Response to Planning Application

From: Arun District Council Greenspace

Application ref: BR/129/21/OUT

Description: Outline application with all matters reserved for 10 new dwellings consisting of 1 No. 1 bed property, 8 No. 2 bed properties and 1 No. 4 bed property with associated services, landscaping, car parking & amenity (resubmission following BR/190/20/OUT).

SITE PLAN (PROPOSED) 1:200

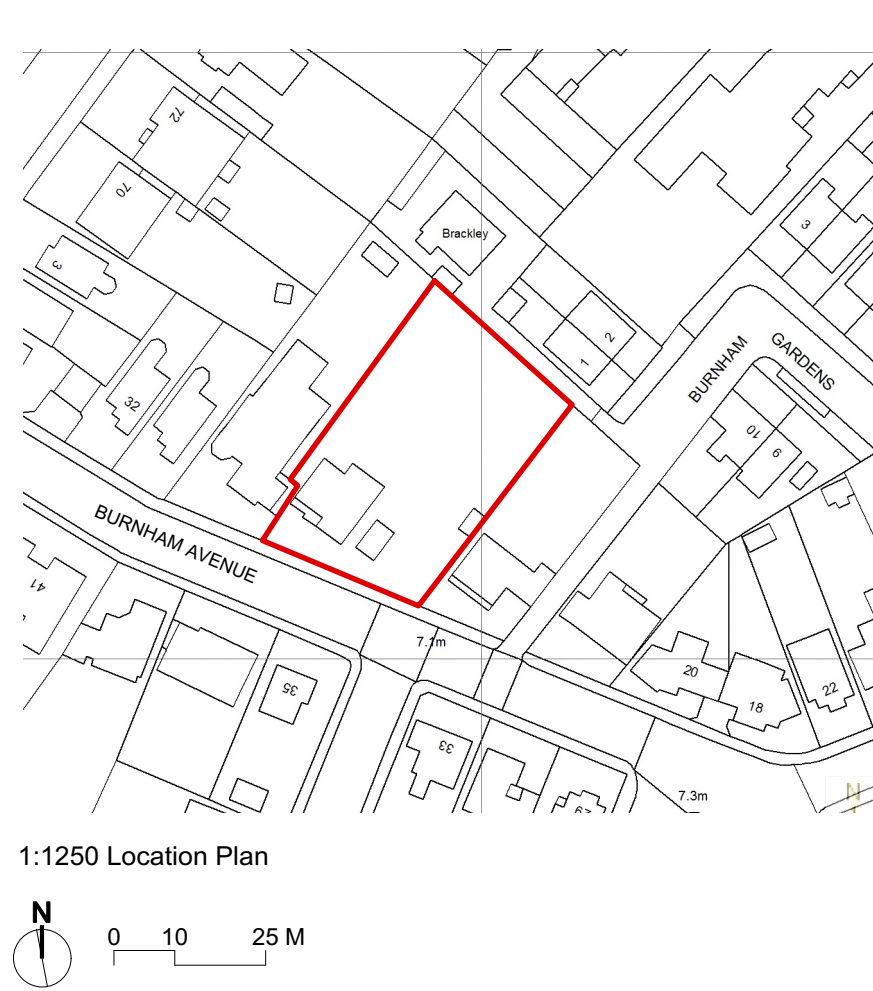
There would be considerable effect on the street scene with these proposals. The proposals indicate that some removal of greening to the frontage would be required for the development. The proposals show the retention of established trees within the rear of the property, these would require protection during construction if they are to remain undamaged. Any tree removals would need to be in consultation with Arun District Councils Tree Officer.

The existing trees in particular along the boundaries and to the north/east of the proposals provide potential valuable screening and could be compromised by these proposals. Root Protection Areas (RPA) should extend into the development site and to those in neighbouring land. Before construction, a tree protection scheme must be in place for any adjacent trees whose root protection areas fall within the construction zone from neighbouring land. This should be in accordance with BS 5837:2012 'Trees in relation to construction'

There would appear to have been consideration within this application for communal amenity outdoor space which is good to see. There would be requirement for the submission of a landscape scheme which should be submitted for approval, detailing plant species choice, position, densities and size at time of planting. This should be plotted in plan and list form and in relation to the trees and vegetation to be retained in the locale, so that a clear picture of the proposals can be seen. These details are required to assure the proposals are appropriate to its setting and to ensure that appropriate screening is provided, maintaining and uncompromising the setting and ensuring that the proposals fit within the area of neighbouring and adjacent properties.
